Consultation response from Highways England

Site: Rustington Golf Centre, Golfers Lane, Angmering, BN16 4NB.

Development: New retail unit with mezzanine together with associated car parking & service road
- This is a Departure from the Development Plan

Planning Application No: A/84/17/PL

Distribution of Traffic on Wider Road Network (East of Site)

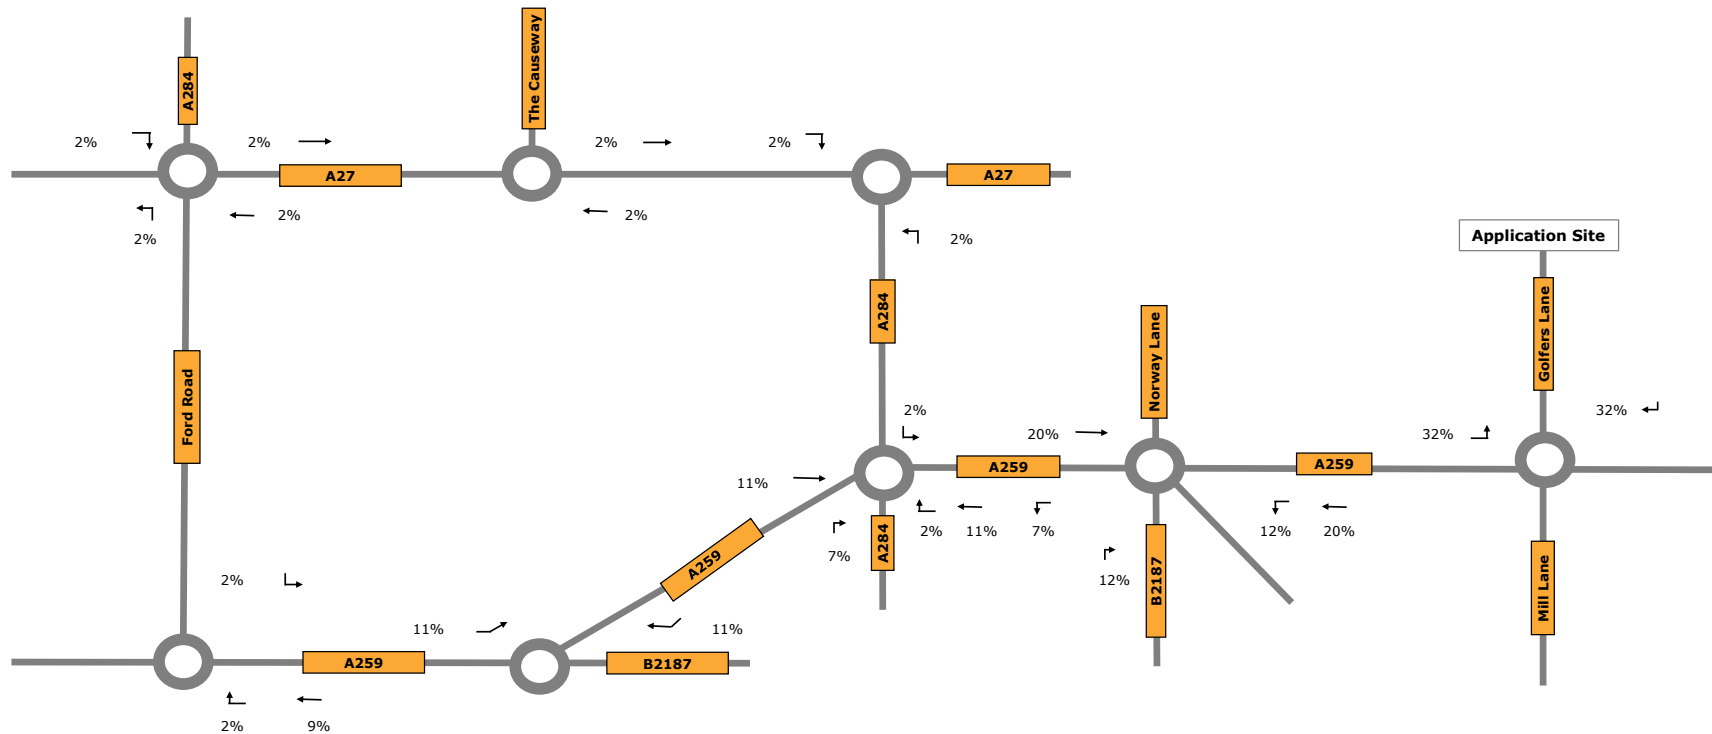
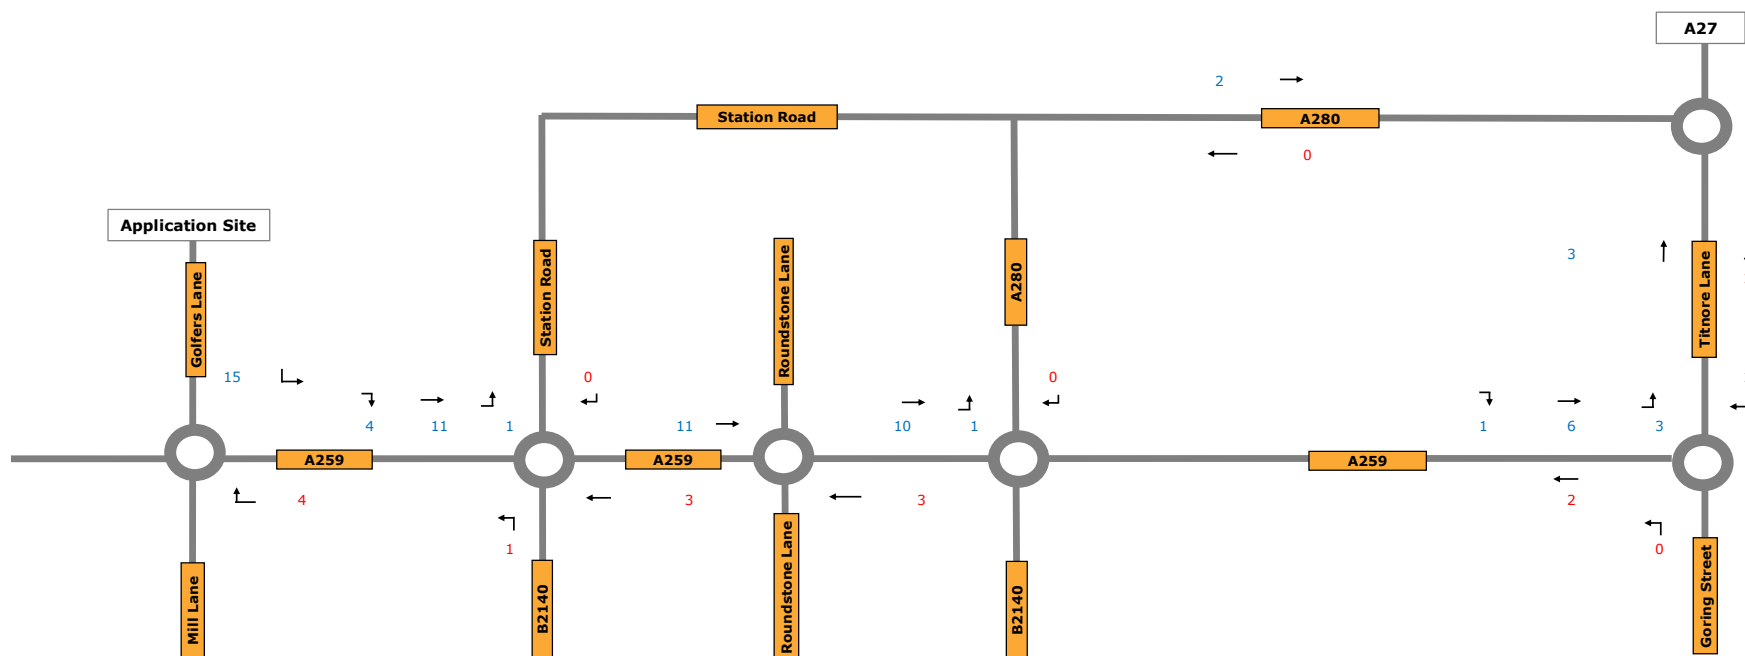
- While the trip distribution has now been considered beyond the closest junctions as far as the A27, we note that:
 - Paragraph 3.1 states that *“employment destinations of the local population has been derived and it has been assumed that the development traffic will disperse in accordance with the data..”*, implying that the distribution of development traffic would be assessed on the basis of it being a trip generator, although Appendix C appears to include data for Arun as an employment destination, which would be more appropriate with the site being a trip attractor, and thus clarification is requested on this.

- Given the specialist nature of the proposed development, Highways England expects that proportionally more traffic would use the A27 junctions than proposed (2% of traffic is predicted to route via the A27 / A284 junction and 14% via the A27 / A280 junction), and thus the use of travel to work data may not be appropriate in this situation. In particular, we note that 12% of westerly traffic has been routed south down the B2187, while 14% of easterly traffic has been routed down the B2140 in addition to the 17% that routes south from the development.

3. The distribution/traffic flows are not considered beyond the closest roundabout and thus it is not clear how many trips are expected to end up at the A27 and no consideration has been given to the impact of the proposed development on the SRN (A27), particularly in relation to the other strategic development contained within the emerging Local Plan.
